Project #: 1001941

Application #: 13DRB-70490

Project Name: ALVARADO GARDENS UNIT 1

**CITY OF ALBUQUERQUE
PLANNING DEPARTMENT
August 6, 2008
DRB Comments**

SKETCH PLAT
LOTS 34-A, 34-B, 34-C AND 34-D
LANDS OF TAYLOR
SECTION 6, T. 10 N., R. 3 E., N.M.P.M.
ALBUQUERQUE
BERNALILLO COUNTY, NEW MEXICO
MAY 2002

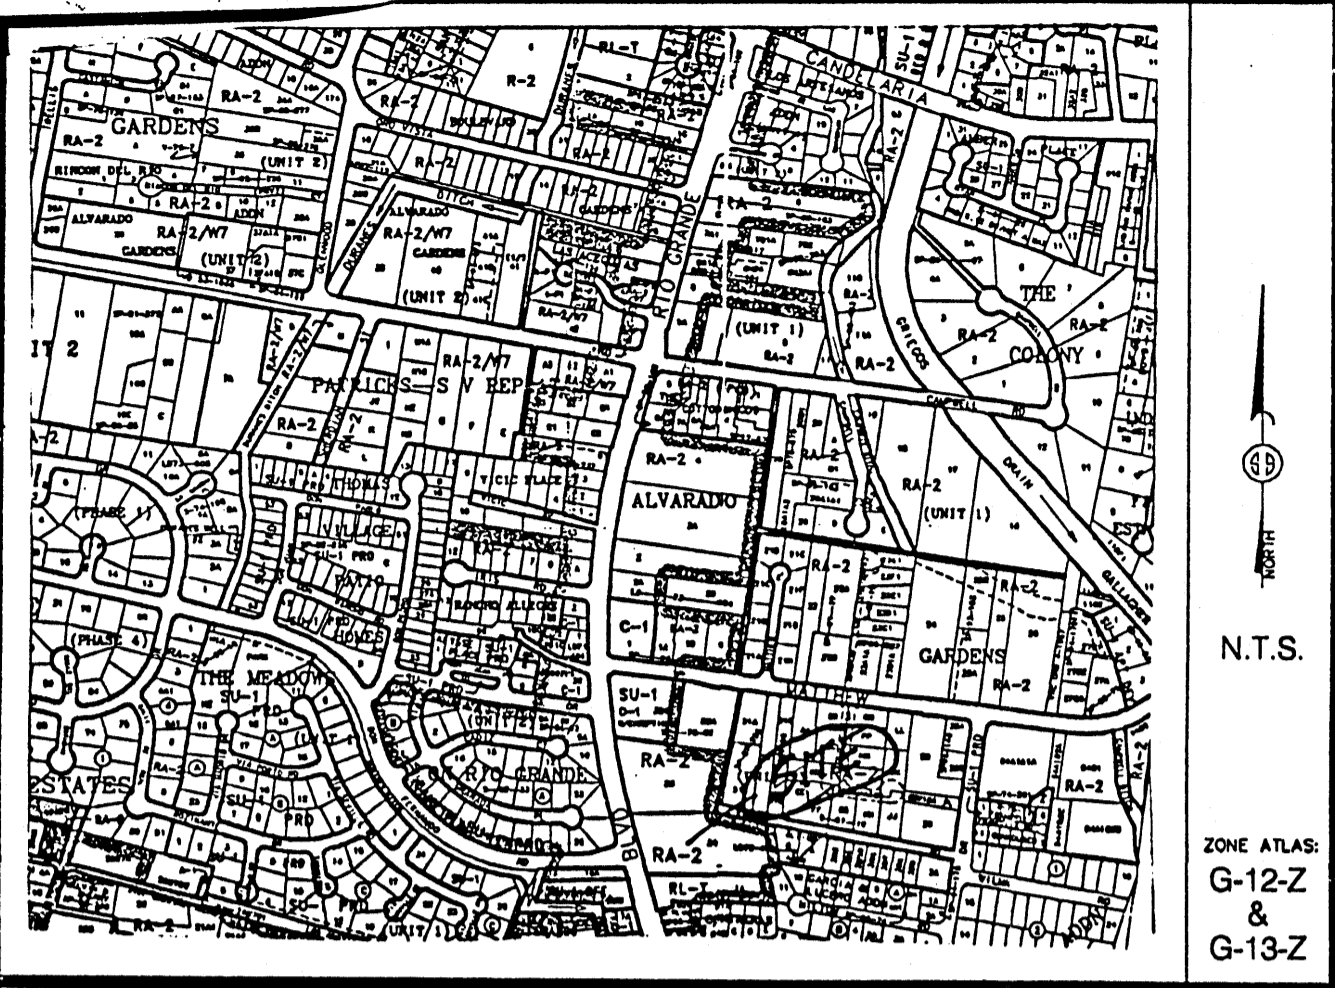
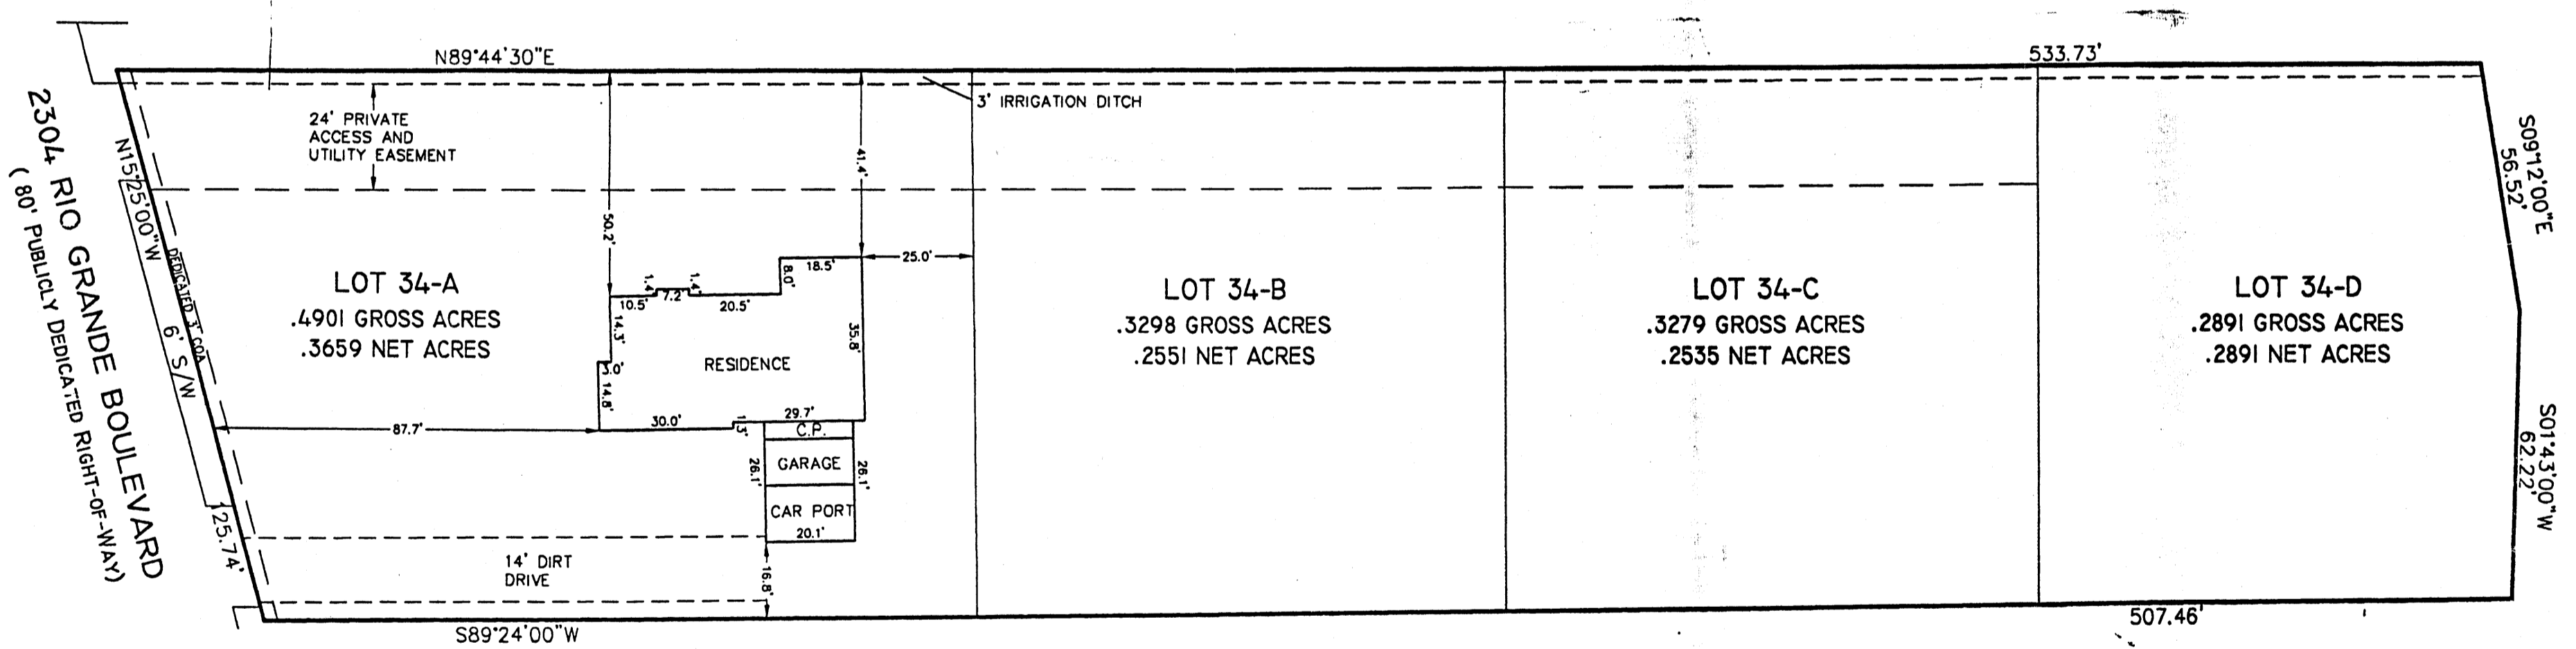
- 1) Rio Grande requires 86' of right-of-way. Dedication will be required.
- 2) What is the width of the sidewalk along Rio Grande?
- 3) Private access to 4 lots requires 32' for one side fronting. (28' may be possible) A 4' sidewalk is required along the private access easement.
- 4) Is there 500' of sight distance at the entrance to Rio Grande?

SKETCH PLAT
LOTS 34-A, 34-B, 34-C AND 34-D
LANDS OF TAYLOR
SECTION 6, T. 10 N., R. 3 E., N.M.P.M.
ALBUQUERQUE
BERNALILLO COUNTY, NEW MEXICO
MAY 2002

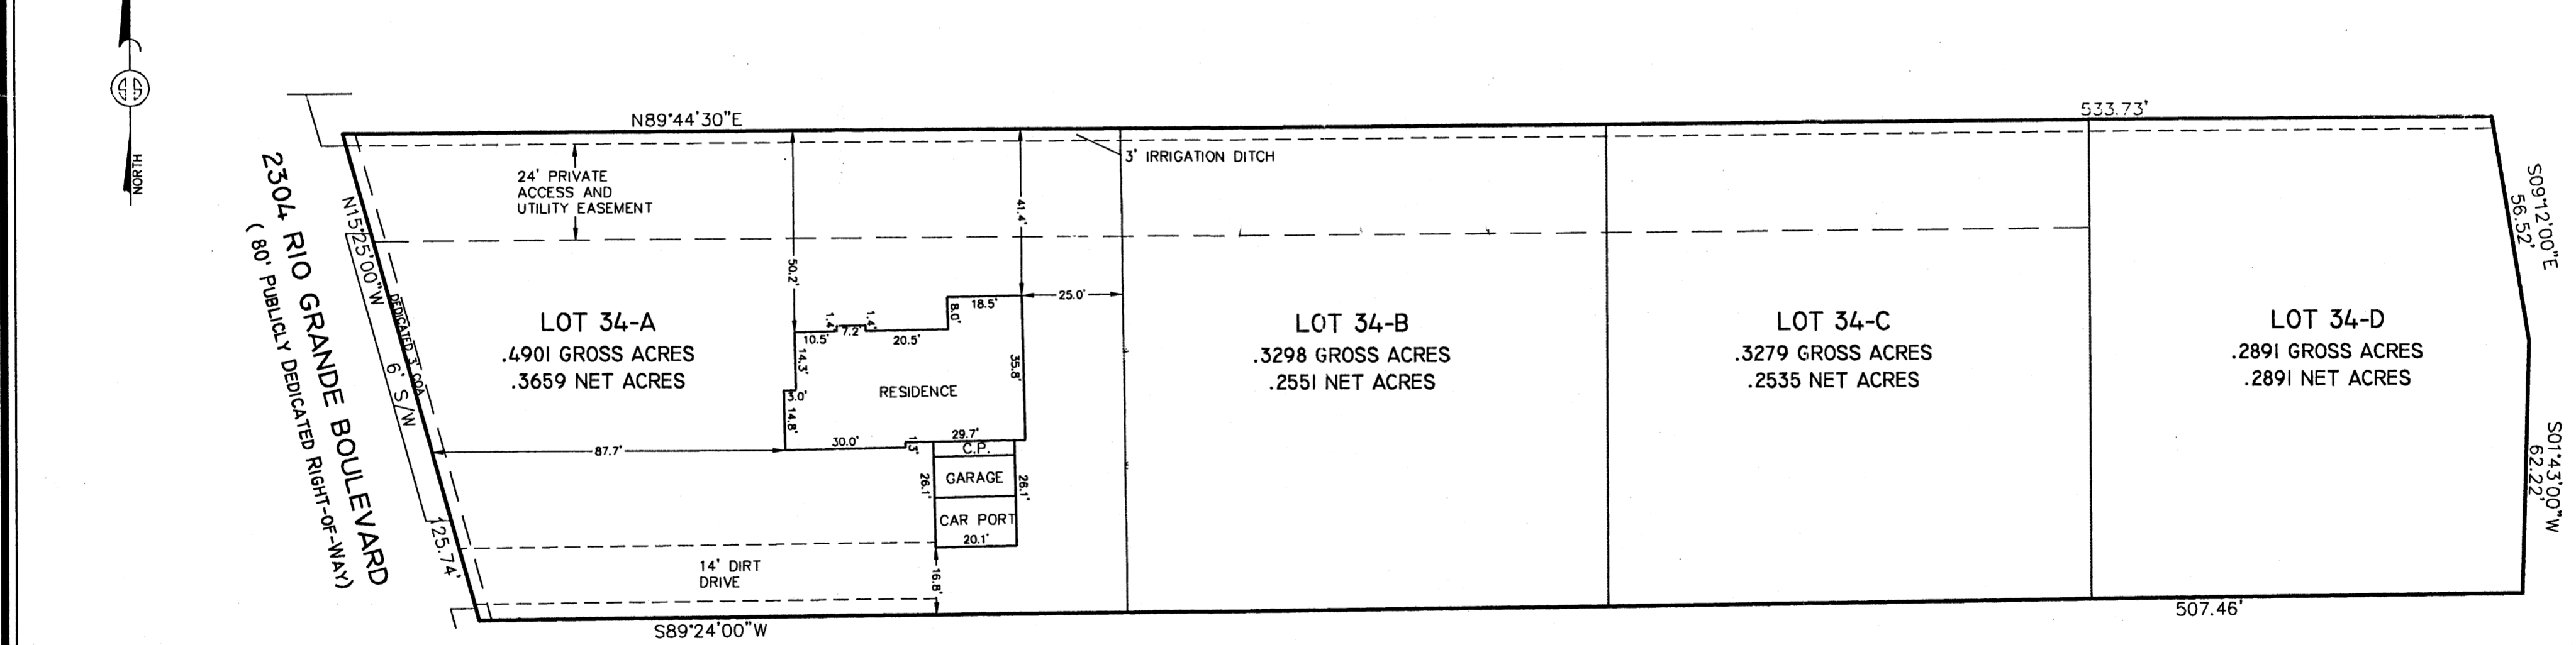
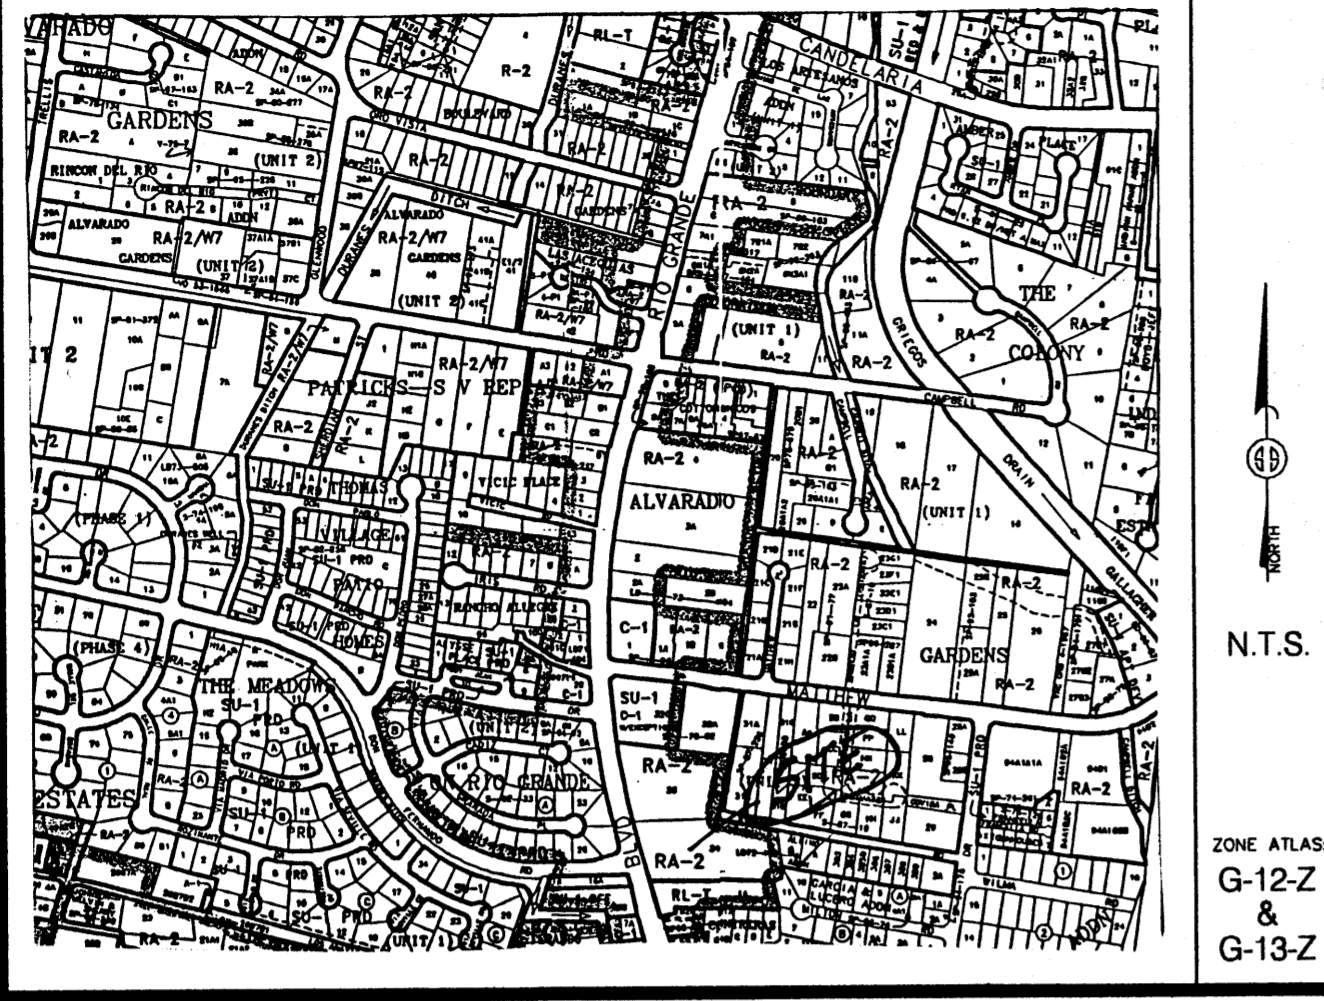
1. Needs on-site public line extensions as well as public water line extension along Rio Grande frontage; see availability letter 6/05/02.
2. Resolve utility billing issues prior to subdivision.
3. Establish status of "south half" of Lot 34 prior to subdivision.

1. The site lies within the boundaries of the Rio Grande Design Overlay Zone identified in the Rio Grande Corridor Plan. Refer to the plan for design guidelines/requirements.

The purpose of this replat is to create two (2) new lots from one (1) existing lot and to provide access to said lots.

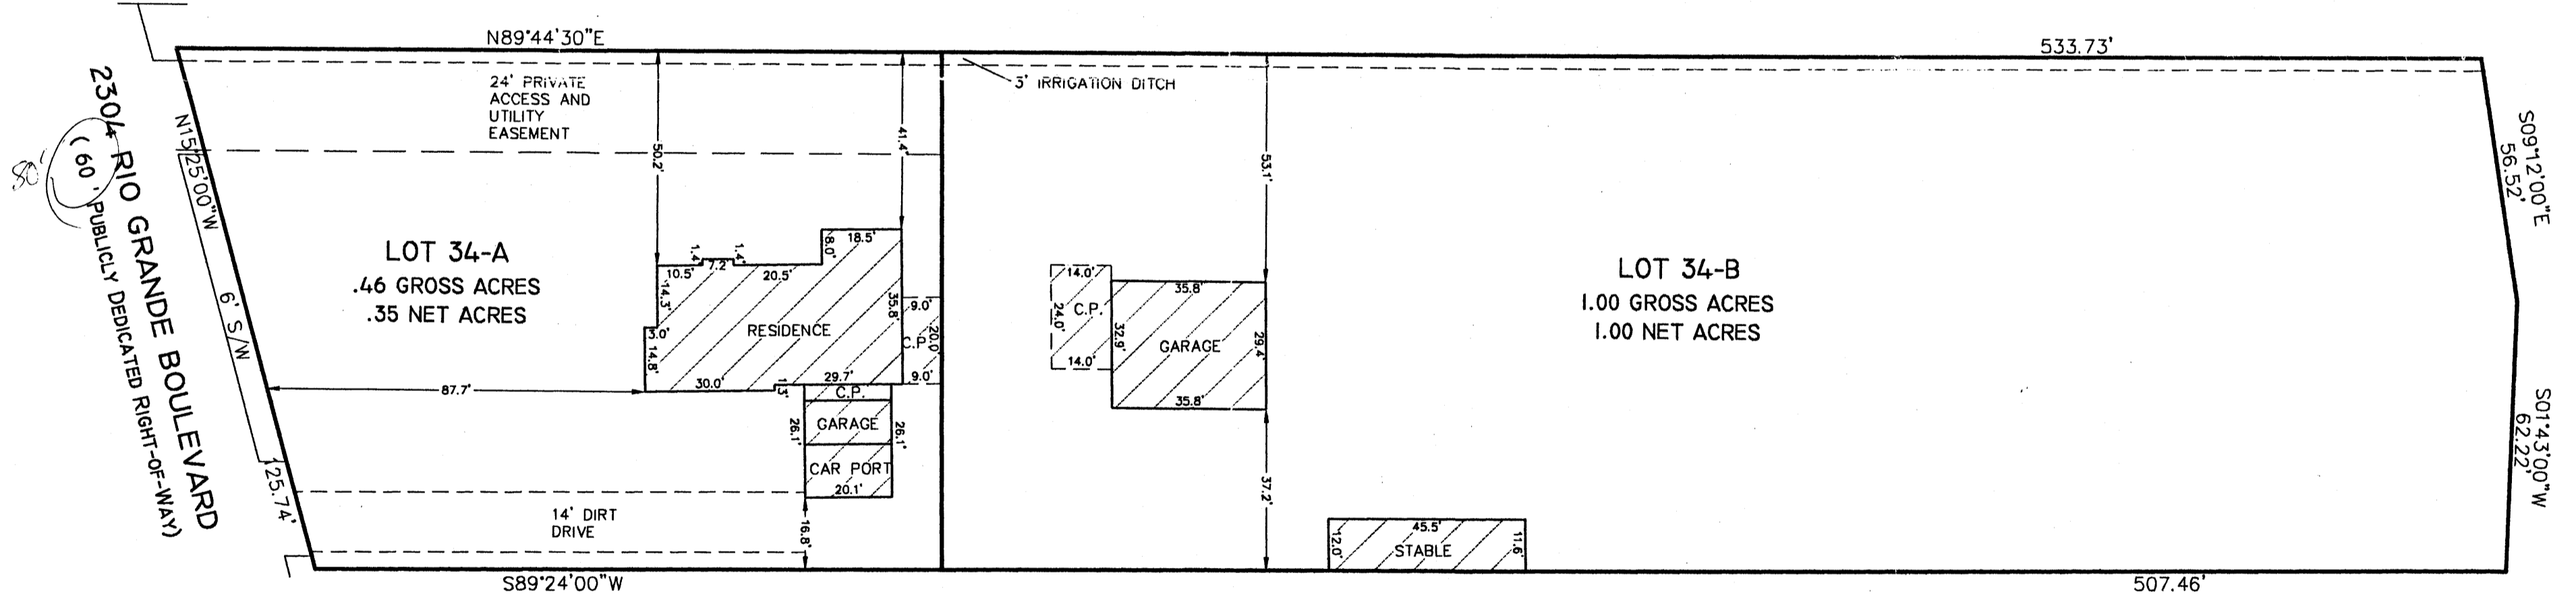
| No. | Comment |
|--------------------------|--|
| <input type="checkbox"/> | Check the right-of-way width on Rio Grande Boulevard, the ultimate width is 86 feet. |

1. Requires infrastructure list for public line extensions.
2. Need to request an availability statement from Utility Development.
